Application No: FG/192/21/HH
Site Address: 37 Ferringham Lane Ferring BN12 5NB
Description of works: Dormer extension

Thank you for your internet representation made on 30th November 2021 which has been recorded as no objection with the comments as follows:

First Floor Plan - Proposed

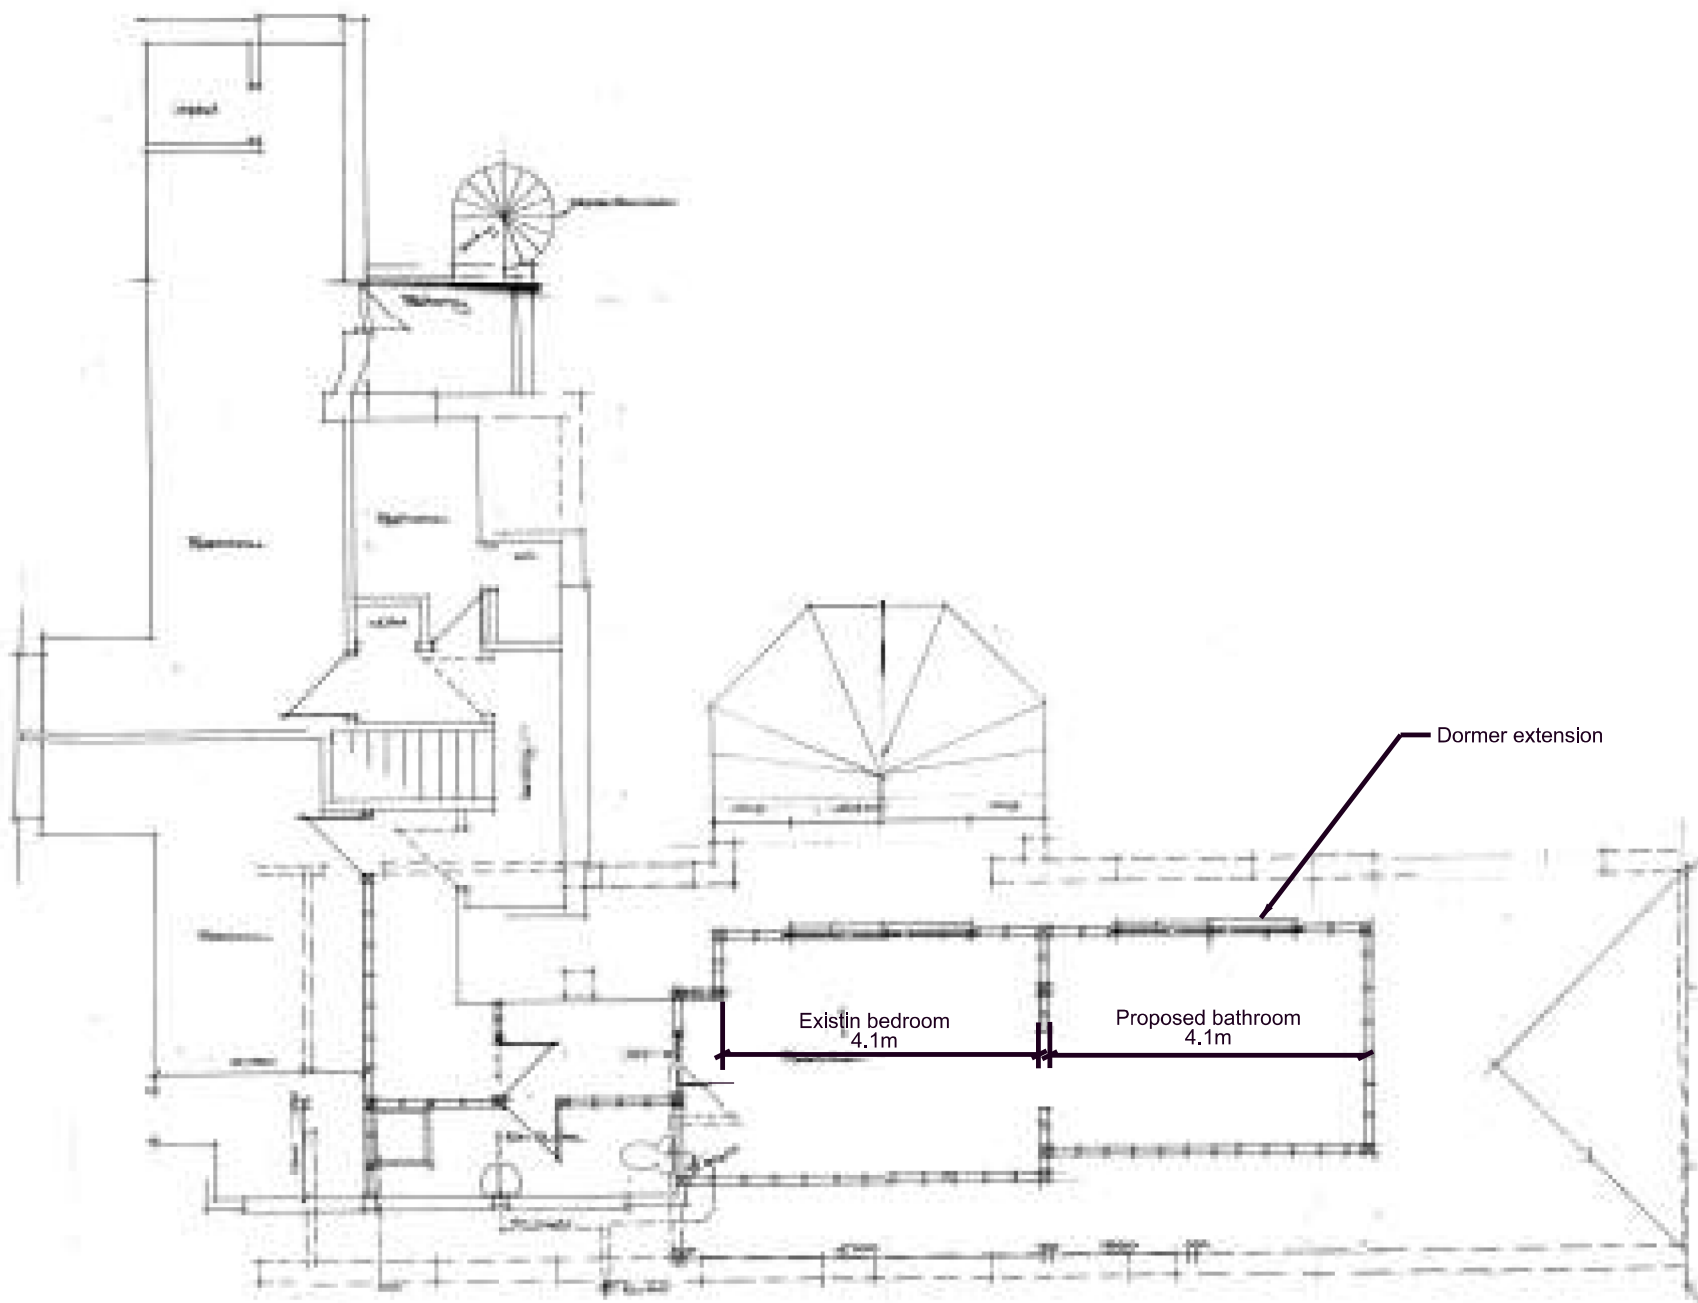
There does not appear to be any indication on the application of the type of glazing to the proposed dormer extension.

In consideration of officers comments on FG/73/21/HH Ferring Parish Council request that should the application be granted, it should be made conditional on the bathroom window being obscure glazed and fixed closed to a minimum height of 1.7. metres.
